September 20, 2013,

**Re: Beehive Homes, SWC Wenonah and Four Hills Rd SE,
Traffic Circulation Layout
Engineer's Stamp dated 9-17-13 (L23-D022)**

Based upon the information provided in your submittal received 9-18-13, the above referenced plan cannot be approved for Building Permit until the following comments are addressed:

BEEHIVE HOMES SITE DEVELOPMENT PLAN DETAILS Rio Grande Engineering 1606 CENTRAL AVENUE SE SUITE 201 ALBUQUERQUE, NM 87106 (505) 872-0889	DRAWN BY WCWJ
		DATE 3-02-13
		21227-LAYOUT-7-13-12 SHEET # 2 JOB # 21227

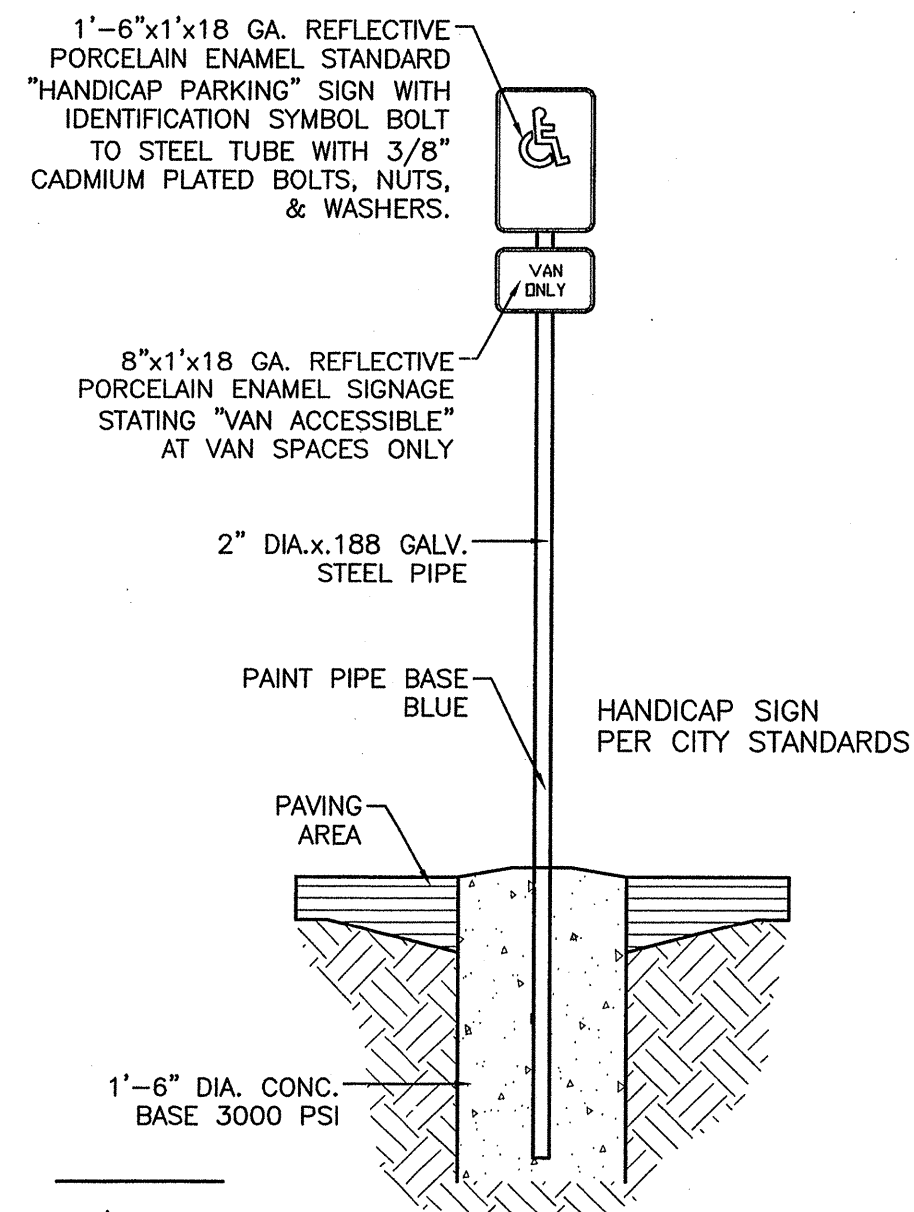
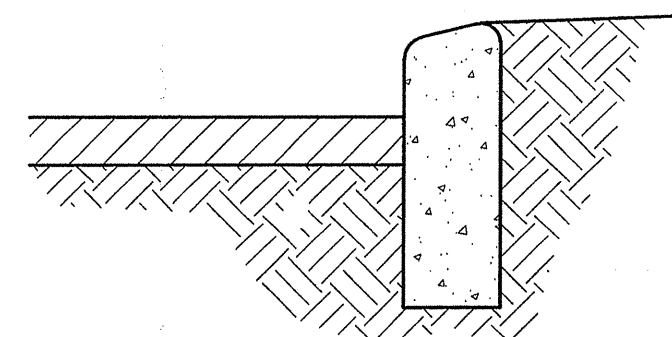
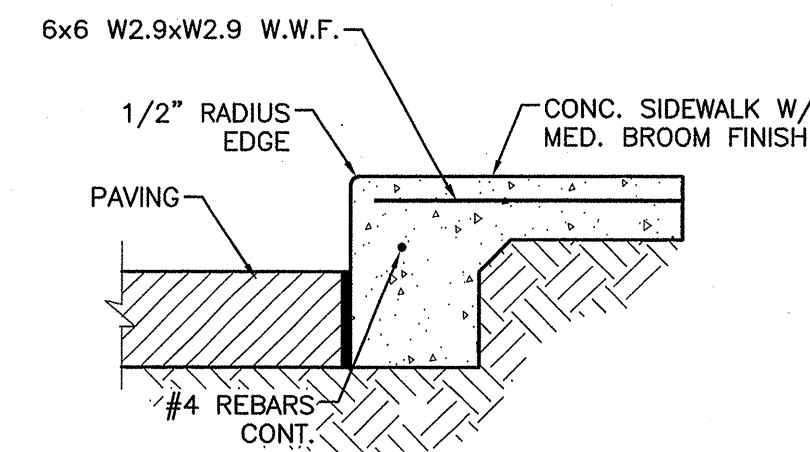
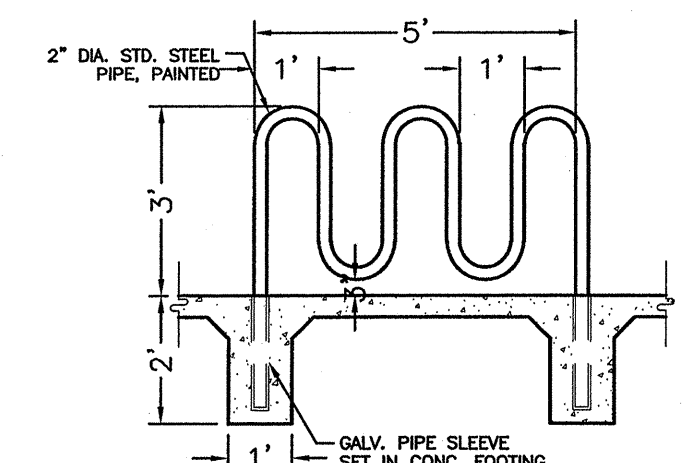
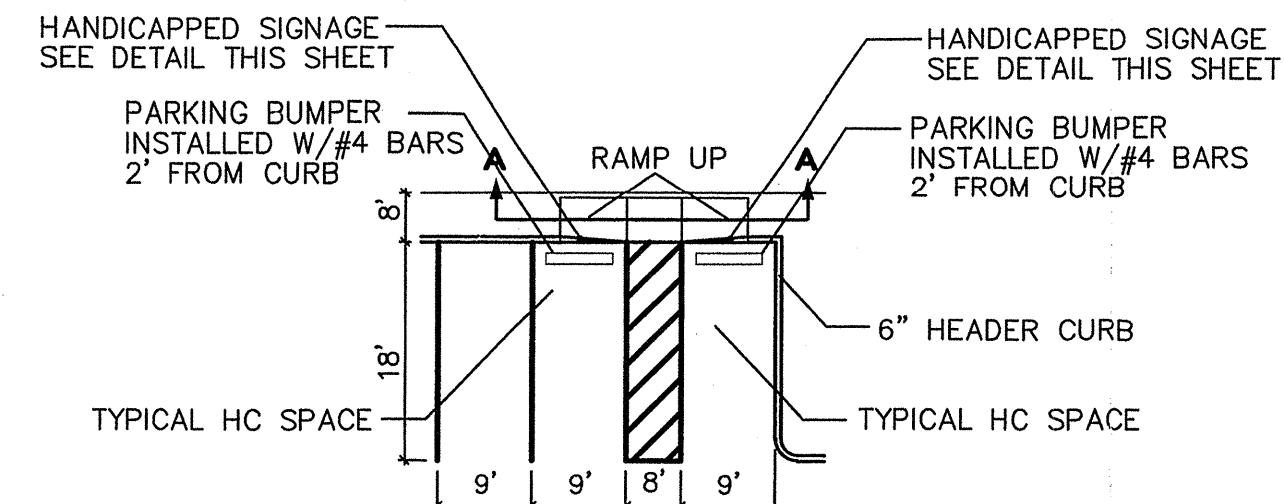
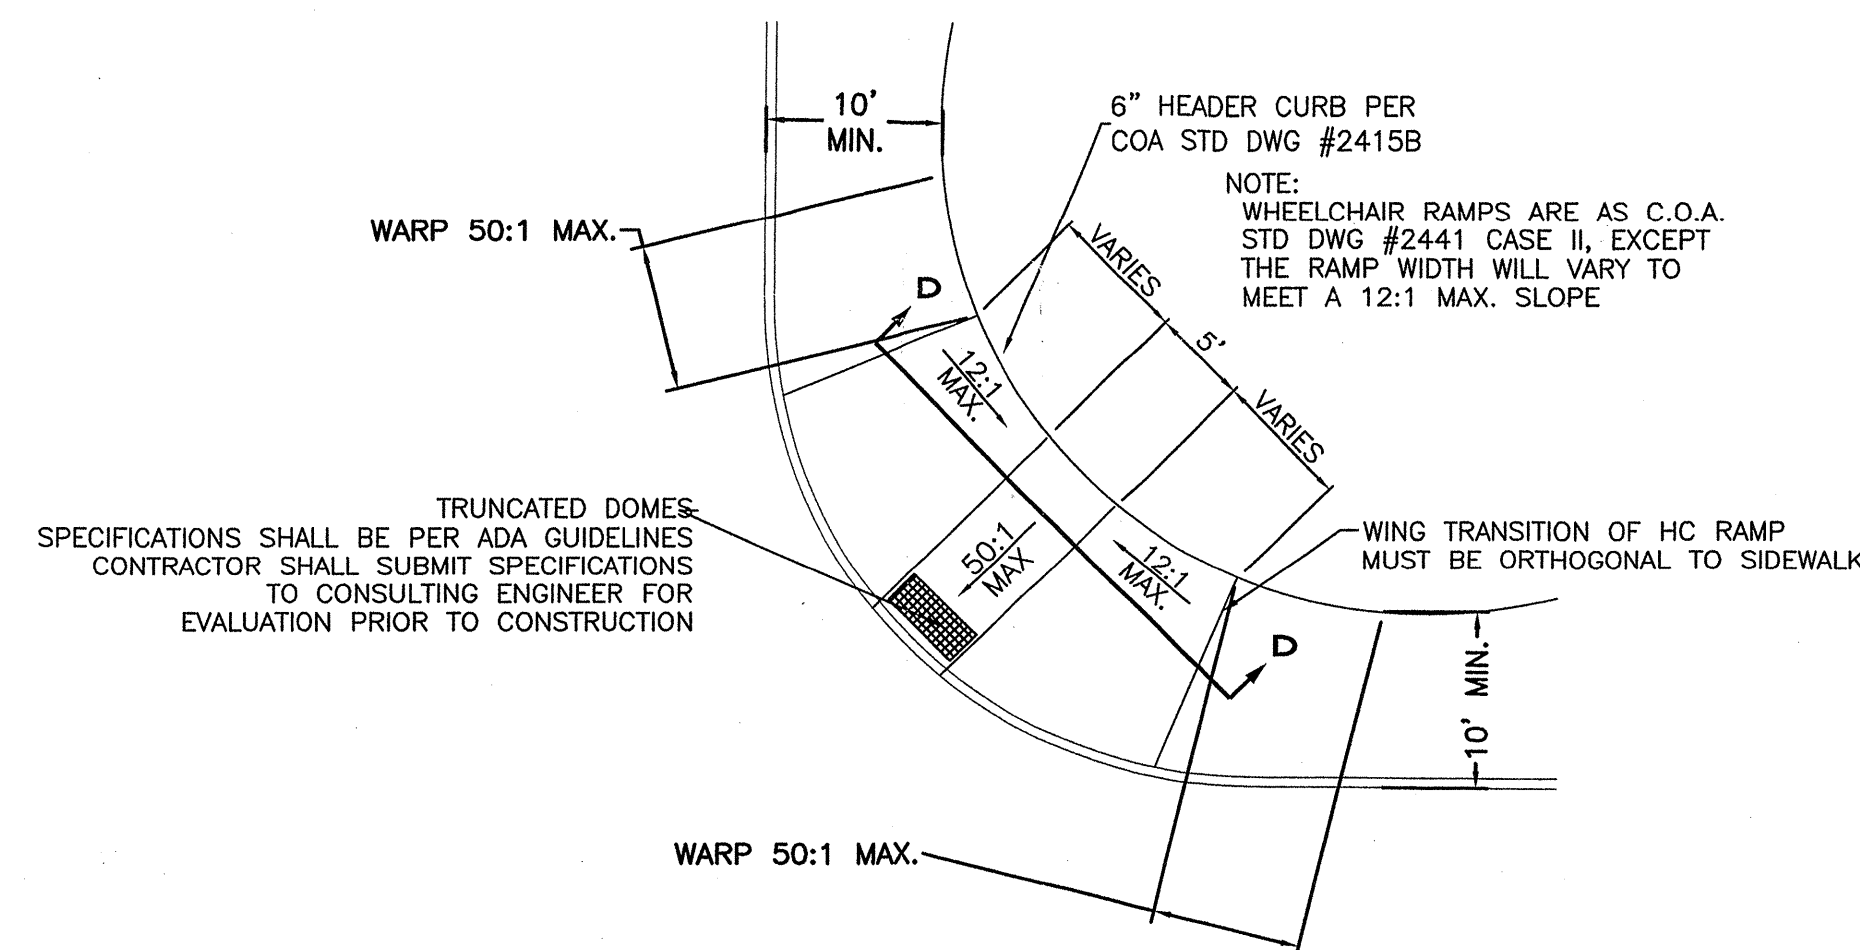
1. Please refer to all applicable city standards.
2. Please ensure all ramps are ADA compliant.
3. Please include a copy of your shared access agreement with the adjacent property owner.
4. Define width of the existing public sidewalk.
5. Landscaping requires curbing to contain and prevent run-off into vehicle parking areas, vehicular access roads and pedestrian paths. Please clearly label and dimension location of proposed landscaping and related infrastructure.
6. Please define the vehicle access roads from frontage through parking areas: widths, surface treatment, curb and gutter, pedestrian crosswalk treatment, vehicular pavement markings and dead-end treatment.
7. Please clarify intent of "Zero Curb" labels.
